I wish to submit an Observation regarding Shankill Property Investments Ltd.'s Strategic Housing Development application to build on part of the former Bray Golf Club lands at Ravenswell, Bray, Co. Wicklow - Case Ref. TA06D.314686.

**Re: Shankill Property Investment's Application:
Case Ref. TA06D.314686 – Former Bray Golf Club lands**

Title
PROPOSED STORM WATER FLOW PATH DIAGRAM

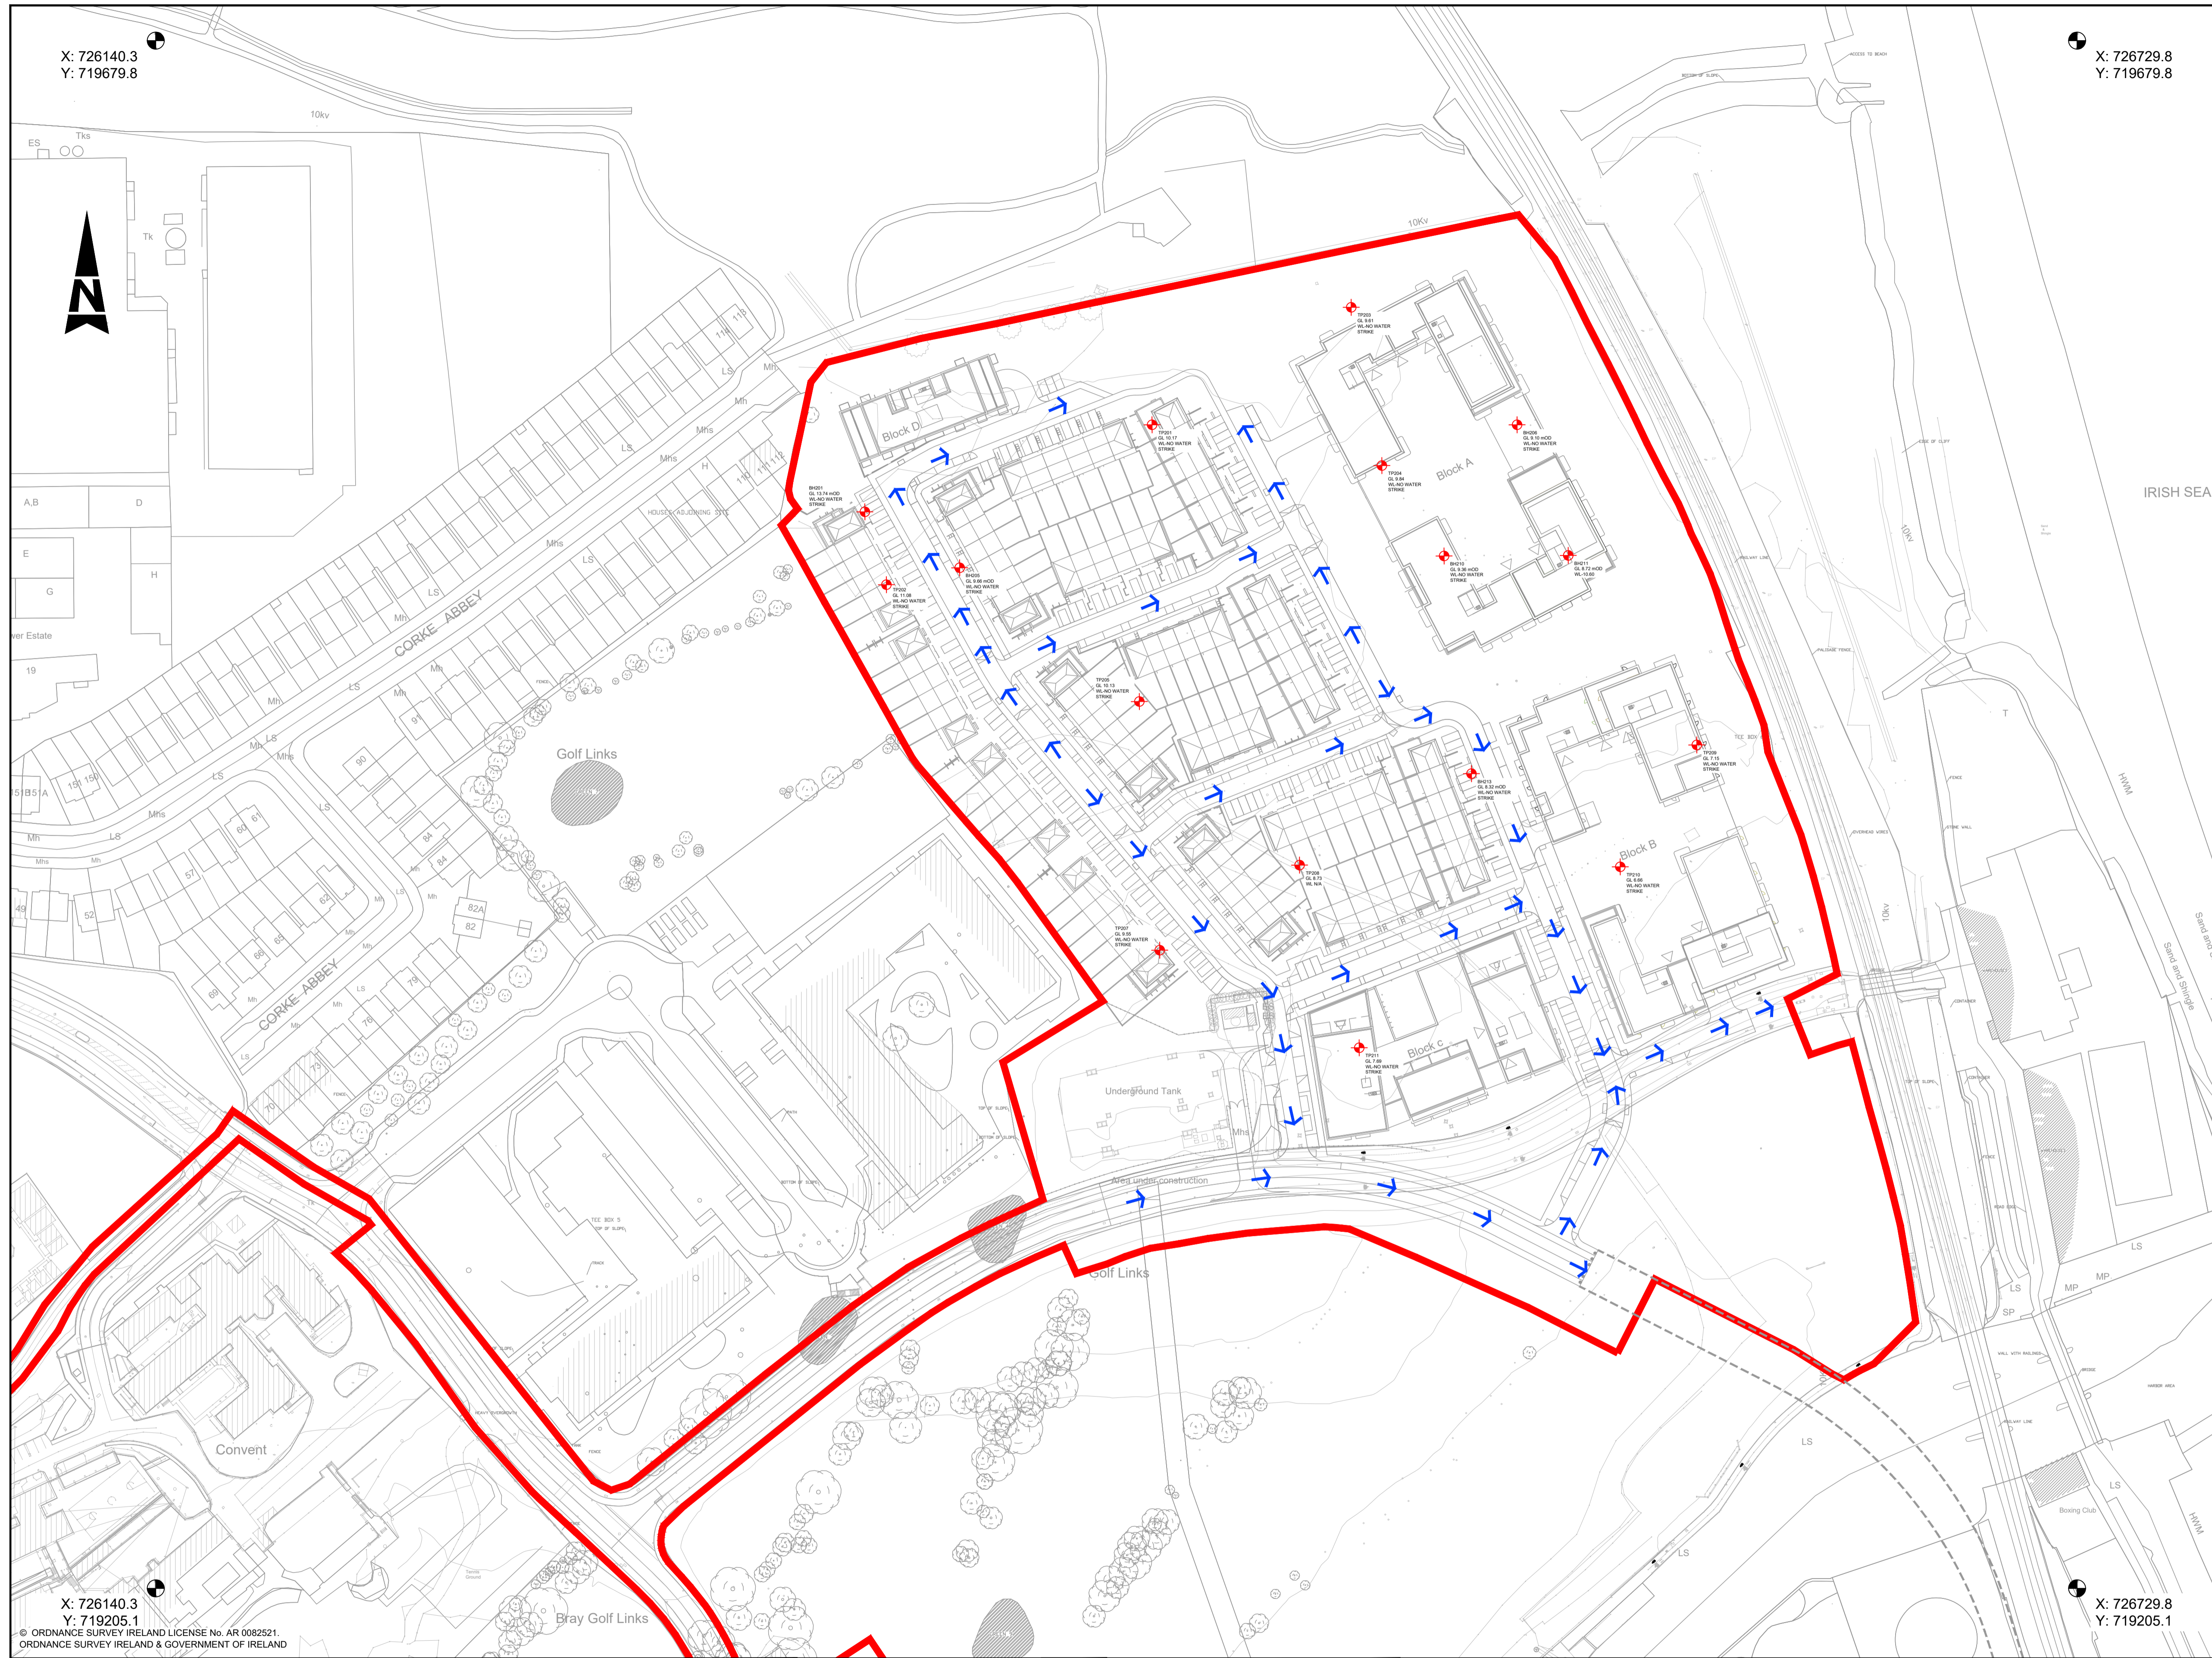
A flood assessment that focuses only on the proposed development and pays no attention to the topography of the surrounding area disregards the safety and well being of the largely vulnerable and elderly community who live up-river by blocking a necessary flow-path from their homes to the sea. In the event of flooding in the low-lying area between the Upper and Lower Dargle Roads the water traditionally escapes through the low area of the golf club lands and is one of the reasons this land hasn't been built on. Flood defences built in recent years are a great comfort but don't prohibit and cannot fully defend against flash floods from the mountains which combined with rising sea levels will over-top the defences and seek the easiest route to the sea, through little Bray and the golf club lands. Putting a very expensive flood defence system in place, and then allowing development on a floodplain downstream, is a failure in planning and contravenes the EU recommendation not to build on floodplains.
